**East Park Energy Solar Project**

**DCO Application 010141**

**Deadline 3 - Phil Wayles responses to Applicant Response to Written Representations**

Figure 1 Grid Connection Corridor Options

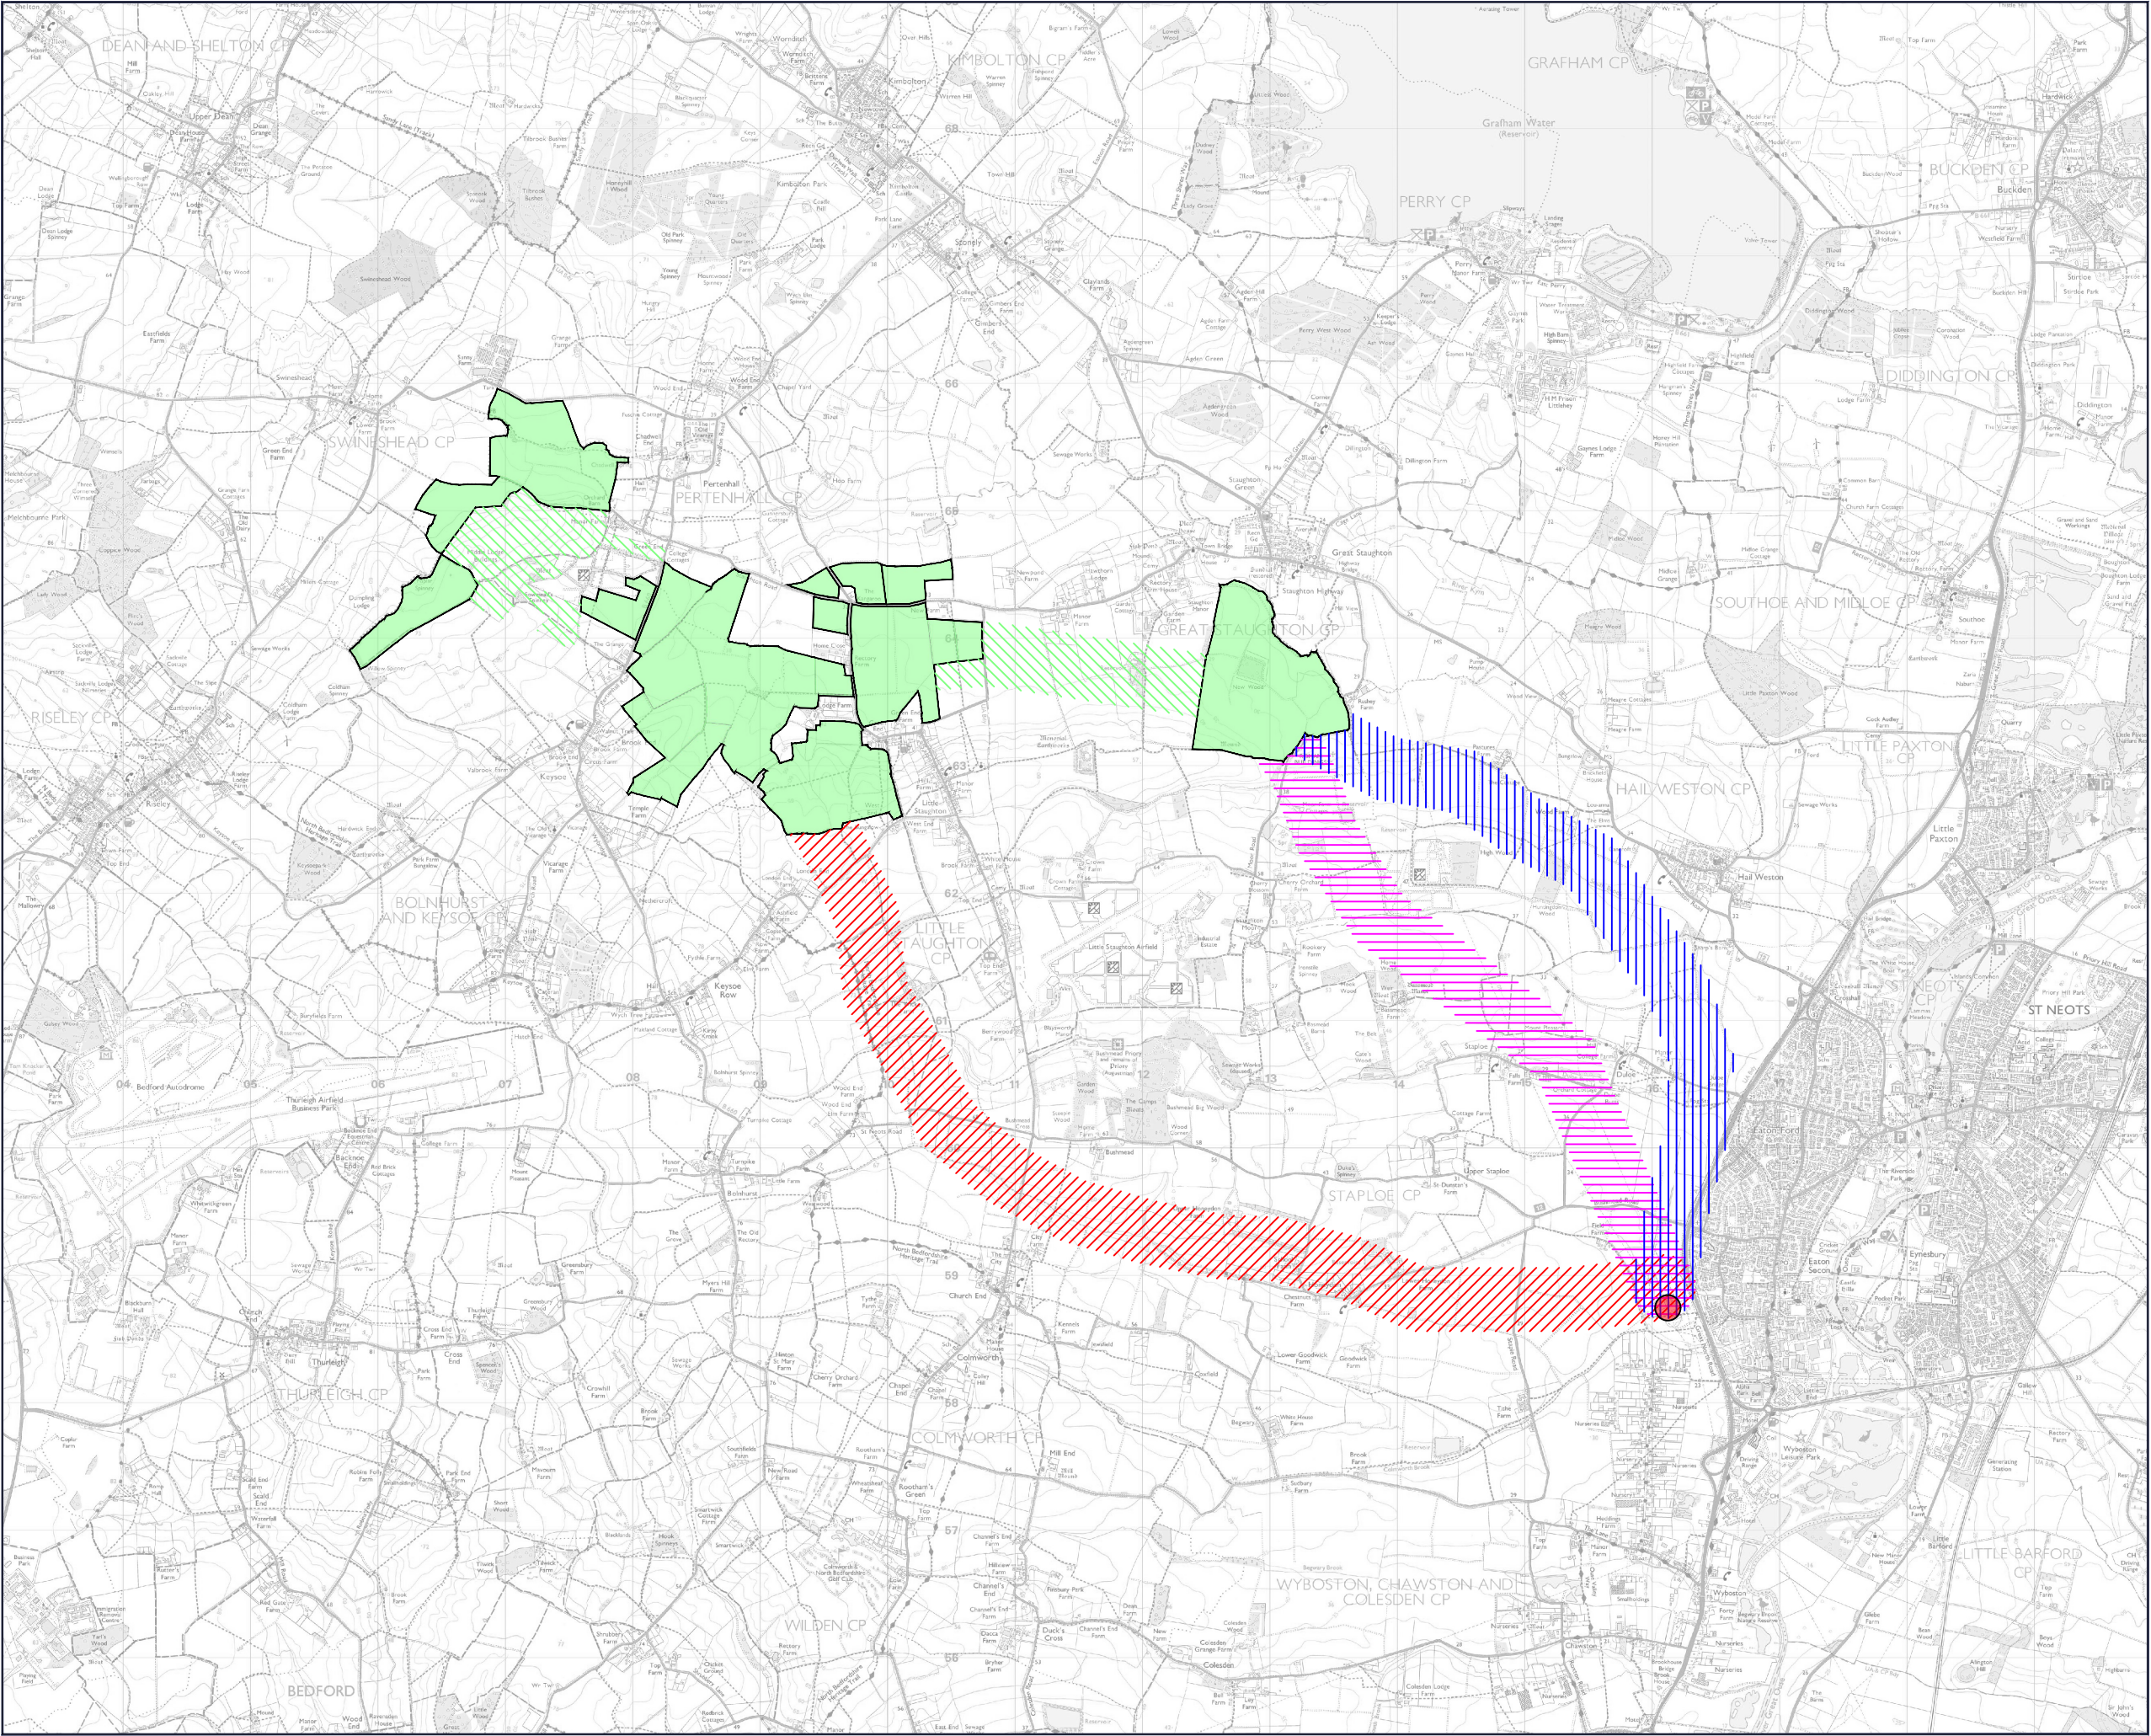
I still maintain the assessment of alternative sites may have resulted in a different outcome if all these factors had been considered.
PW-WR-03	The whole site selection and assessment process and decision to use the Eaton Socon substation as the Point of Connection fails to acknowledge the presence of the Little Barford substation as a reasonable alternative.	<p>Following the widely publicised grid reform process undertaken by the National Energy System Operator (NESO) over the past few years, the Applicant received a ‘Gate 2’ generation connection offer to the Eaton Socon Substation which is 2030 aligned. This connection offer is not transferable to another point of connection, and is not speculative. The connection offer has always been for the Eaton Socon Substation, and that has therefore dictated the site selection process and consideration of alternatives. An alternative point of connection such as the Little Barford Power Station (which has been raised by SEPE as well as other Interested Parties) has therefore not been considered as it is not a viable alternative for this project.</p> <p>Paragraph 4.3.22 of NPS EN-1 is clear that “the consideration of alternatives is to be proportionate and <i>limited to alternatives that can meet the objectives of the proposed development</i>” [emphasis added]. An alternative point of connection to any other substation (including the Little Barford Power Station) would not meet the objectives of this project – such alternatives therefore do not need to be considered by the Applicant. It is acceptable for the assessment to focus on the point of connection that has been offered, and to assess the scheme on that basis.</p> <p>Such an approach was considered by the Secretary of State on the consented Gate Burton Energy Park NSIP – on that case, at paragraph 3.2.77 of the Examining Authority’s Recommendation Report the ExA concluded that it is not an unreasonable starting point for an Applicant to take the agreed point of connection with the grid as a basis for considering alternatives.</p> <p><i>In Bramley Solar Farm Residents Group v Secretary of State for Levelling Up, Housing and Communities [2023] EWHC 2842</i></p>	<p>The response still does not address the issue that the assessment of reasonable alternatives for the Point of Connection and associated appraisal of the Search Zones should have occurred before the substation connection application was made.</p> <p>It is NSIP best practice to undertake a robust and transparent assessment of all reasonable and plausible alternatives solutions. There is no evidence presented in the application that a Point of Connection to the Little Barford power station/substation was not a viable alternative for this project.</p>

PW-WR-05	<p>Significantly, the Point of Connection at the Eaton Socon substation appears to be an issue and is not secured. NGET’s Relevant Representation says, “the substation is currently full and will require expansion, rebuild or provisions of a new substation to facilitate future connections (this includes the Project)”. This questions the viability of the East Park Energy scheme</p>	<p>Following the widely publicised grid reform process undertaken by the National Energy System Operator (NESO) over the past few years, the Applicant received a ‘Gate 2’ generation connection offer to the Eaton Socon Substation which is 2030 aligned.</p> <p>A Grid Connection Agreement is a firm obligation by National Grid Electricity Transmission (NGET) to enable the Applicant to connect the Scheme to the NGET Eaton Socon Substation. This is clearly defined and there are no uncertainties in respect of this and NGET is under a contractual obligation to ensure that the Scheme is connected to the substation.</p> <p>Due to planned upgrade works to the substation NGET has been unable to confirm the exact point of connection for the Scheme</p>	<p>It would be helpful if the Applicant could set out the timeline for EPE construction, the Gate 2 connection process and how this aligned with the work required for the expansion, rebuild or provision of a new substation at Eaton Socon.</p> <p>I note the BESS status is Gate 1 and does not have a guaranteed connection.</p>

<p>within its current substation to date; however, it will be necessary to connect the East Park Substation (Work No. 3) to the NGET Eaton Socon Substation via 400 kV cable (Work No. 4). This does not mean that the cable route between panel areas or from the Applicant's proposed onsite substation to NGET's substation is uncertain. The only uncertainty is in respect of the exact point of connection within NGET's substation and it represents a small proportion of the land the Applicant seeks to develop. This has no impact on the viability of the Scheme.</p>	
PW-WR-07	<p>It remains unproven if the soil quality of the site when reinstated will achieve the same BMV land classification following decommissioning of the site.</p> <p>I am uncertain why the NFU have not been consulted not commented on this important policy matter.</p>	<p>The <b>oSMP [REP1-044]</b> secures a detailed soil management framework for construction, operation and decommissioning, including like-for-like stripping, segregation, storage and replacement of topsoil and subsoil, restoration of soils to the same parcel, protection of field drainage, and monitoring to verify against pre-construction condition.</p>	<p>The lack of precedent on other solar farms (let alone for the soils in this area) remains a concern as does which company will actually be responsible to manage / do this work following decommissioning.</p> <p>No response was provided as to why the NFU have not been consulted nor submitted representations on the important matter of BMV and food security versus construction of so many solar farms in the area.</p>
